### Fire Marshal Comments

Project: Cavalry Baptist Phased Expansion  
Permit#: CU-22-00002  
Occupancy Type: Assembly, Education  
Date: 06/06/2022

Calvary Ellensburg Proposed Site Plan Phase I - Exhibit B

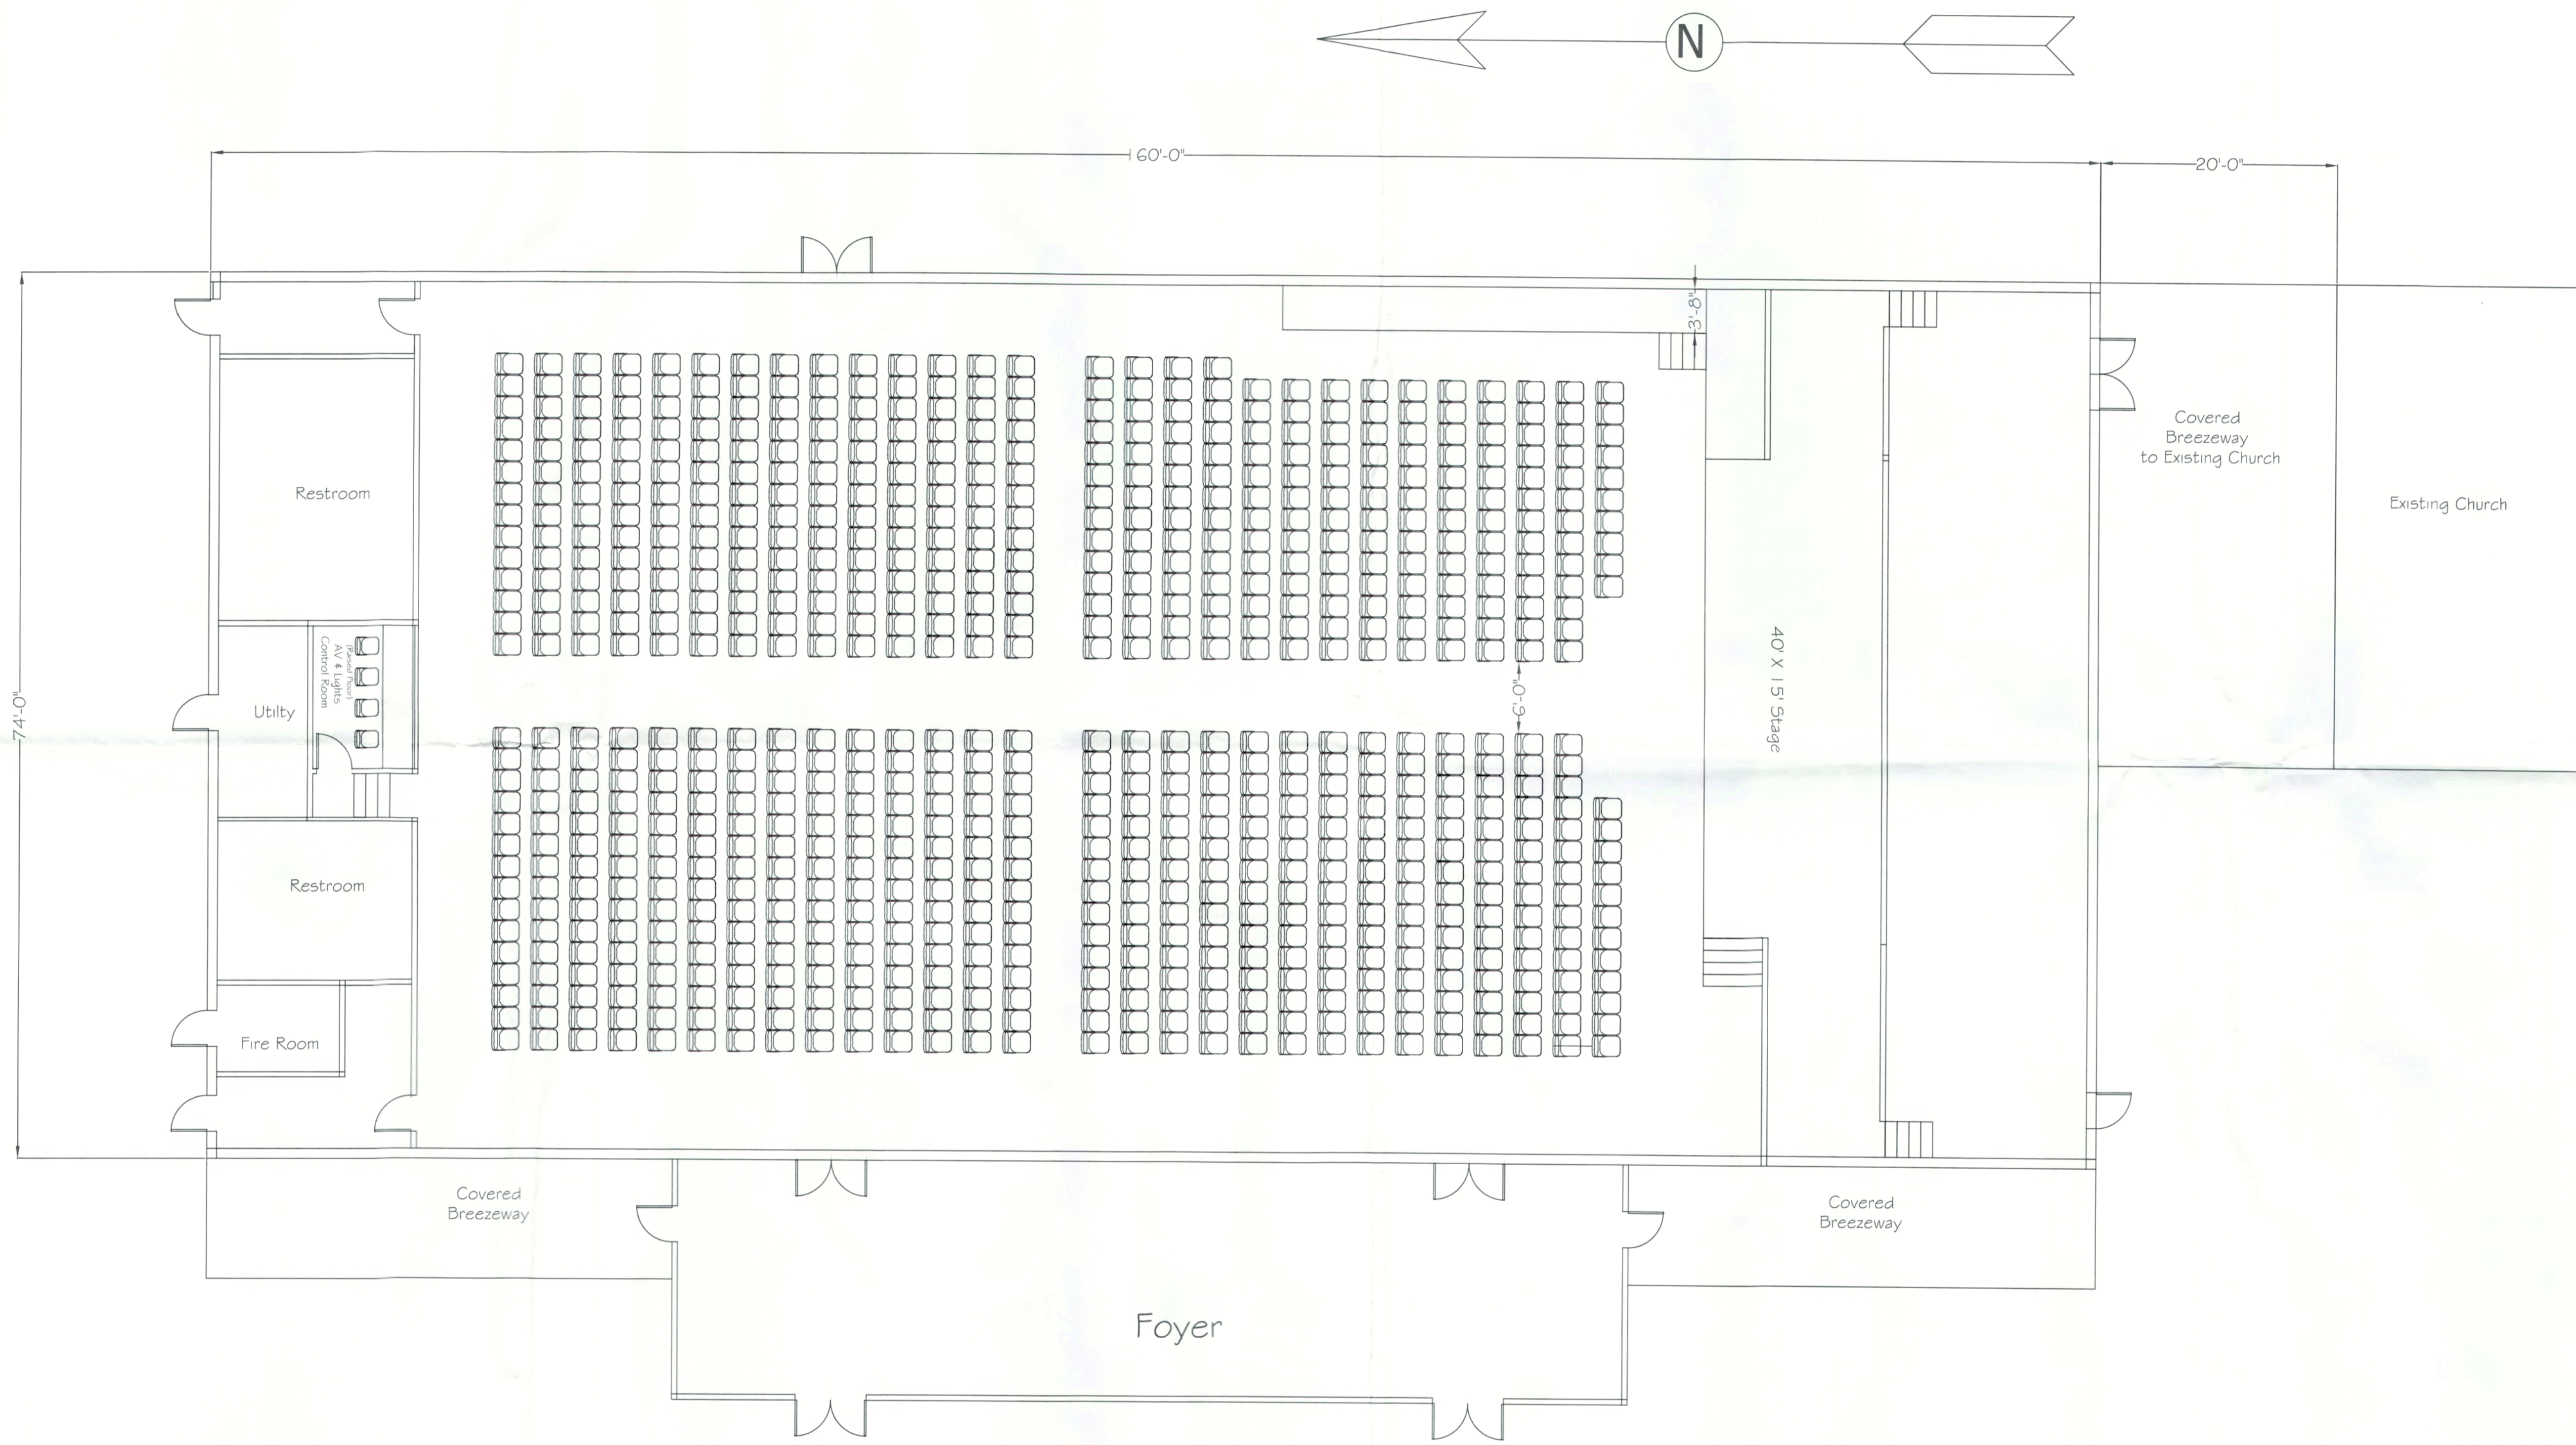
2. Standard Addressing per City Code requirements to include Building and access point numbering or signage to meet IFC requirements.
3. Fire dept. access and turnarounds per IFC Section 503 and Appendix D. Fire department access roads shall be a minimum of 20' wide, access roads shall be a minimum of 26' wide in the vicinity of fire hydrants or meet the City Street Standard if greater. It may be required to post "No Parking Signs" on one or both sides of the fire access road depending on width. Fire dept. access roads cannot exceed 150' in length without an approved turnaround per IFC Appendix D. Road surfaces must be rated for a minimum of 75,000 lbs. or City of Ellensburg street standard if it requires a higher rating. Fire Dept access roads shall provide access to within 150' of all portions of the building(s).

8. Fire Hydrants based on sq. ft. of buildings and required flows based on IFC Section 5, Appendix B and C. As currently designed the site would require additional hydrants. There must be a hydrant within 100' of FDC connections. Consult City of Ellensburg Fire Marshal for preferred location.
